CD V_2.pdf Markup Summary

GEC V_2.pdf Markup Summary

**OFFSITE GRADING & POND C3
 FINAL GRADING AND
 EROSION CONTROL PLAN**

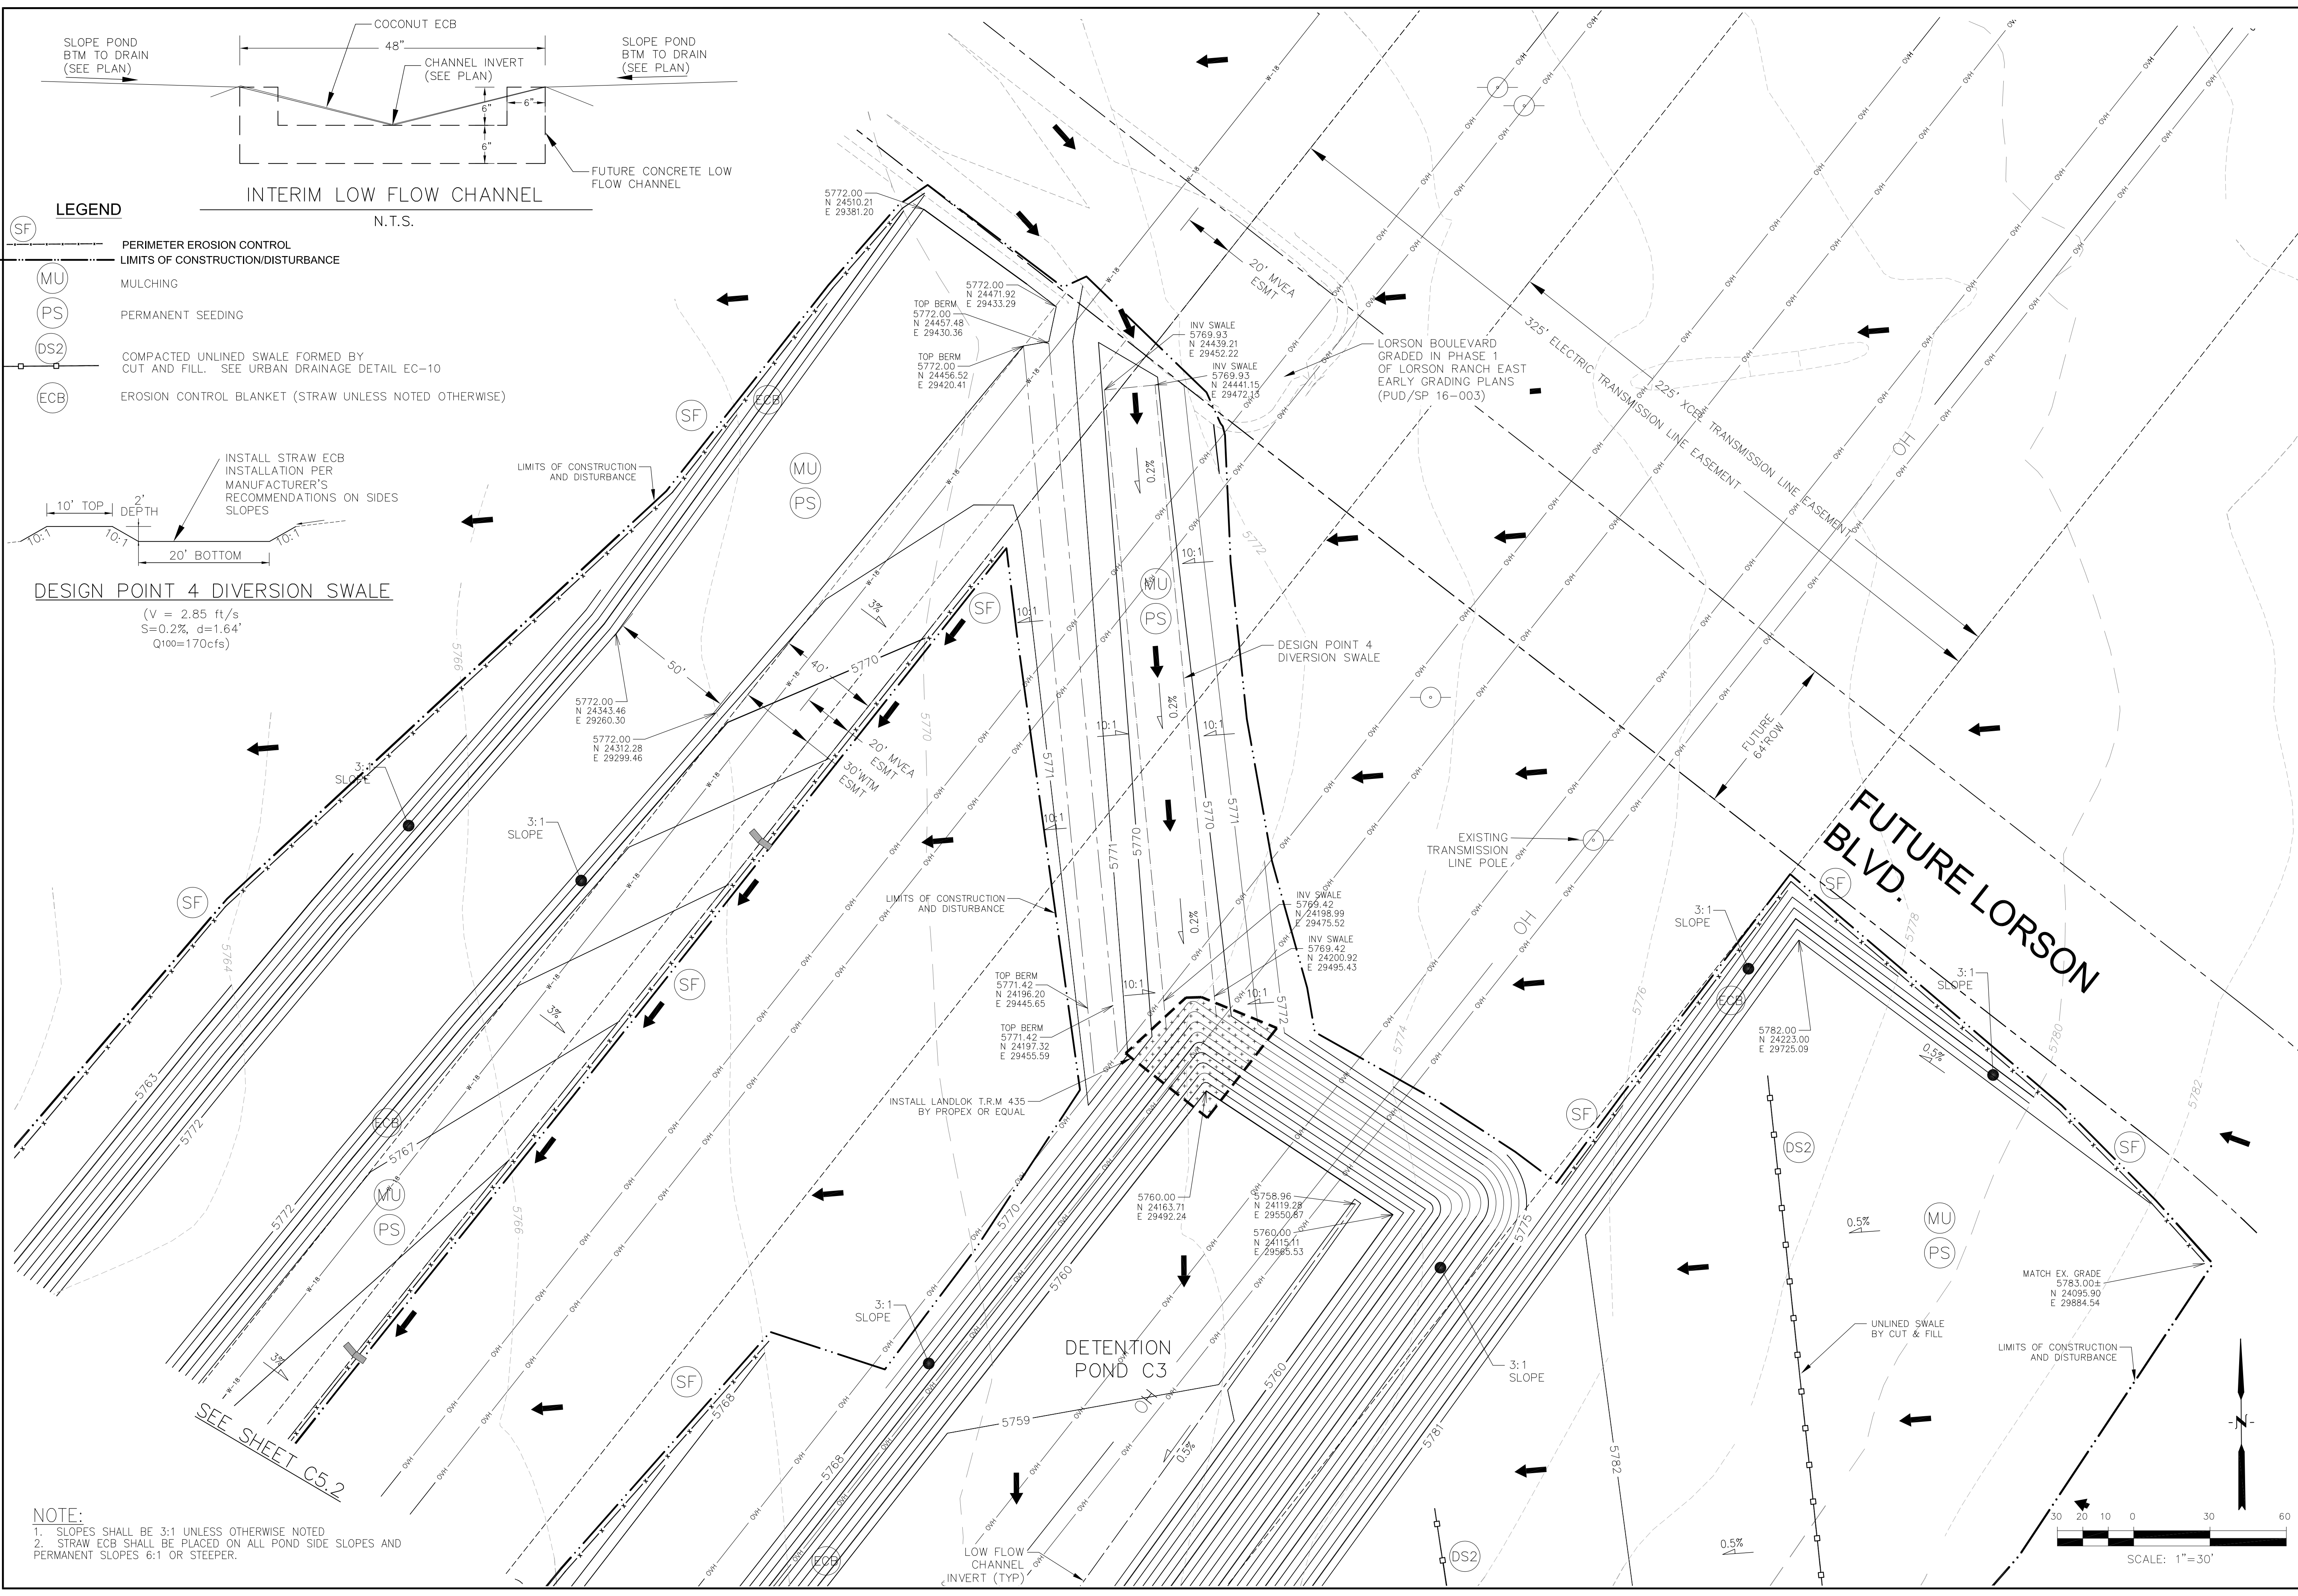
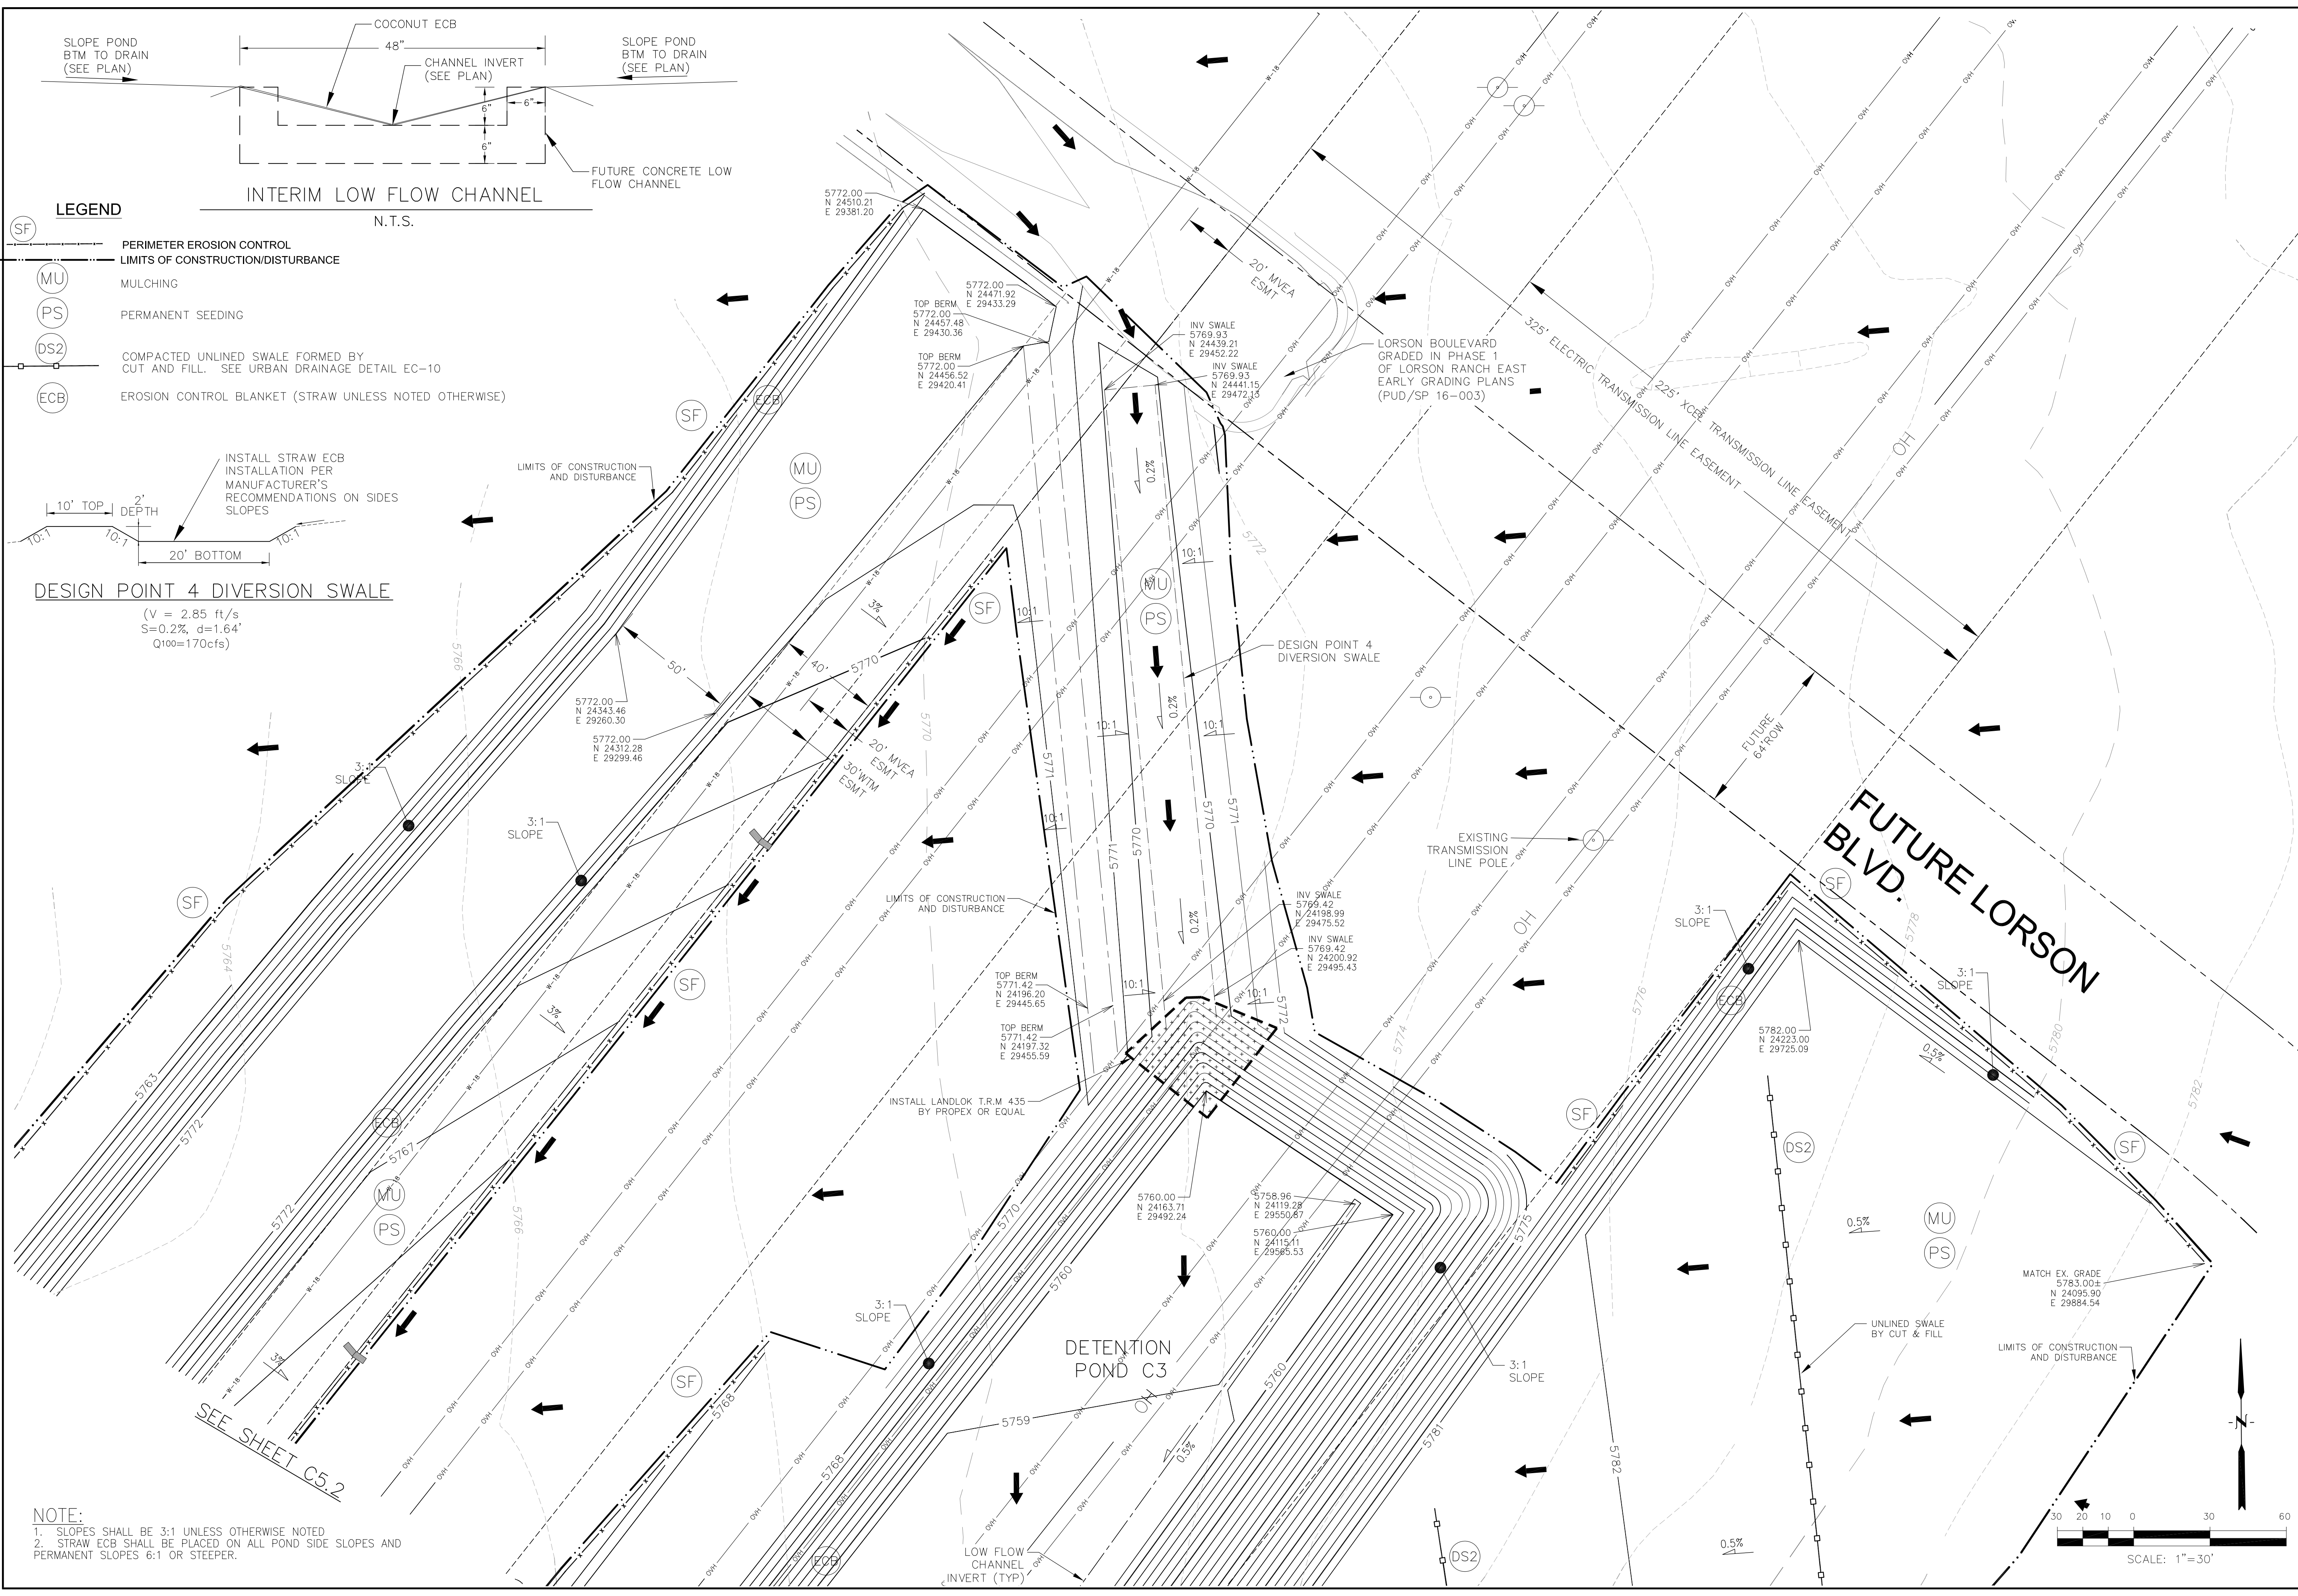
This silt fence could cause erosion flowing downhill along it.

What is contributing area/flow here?
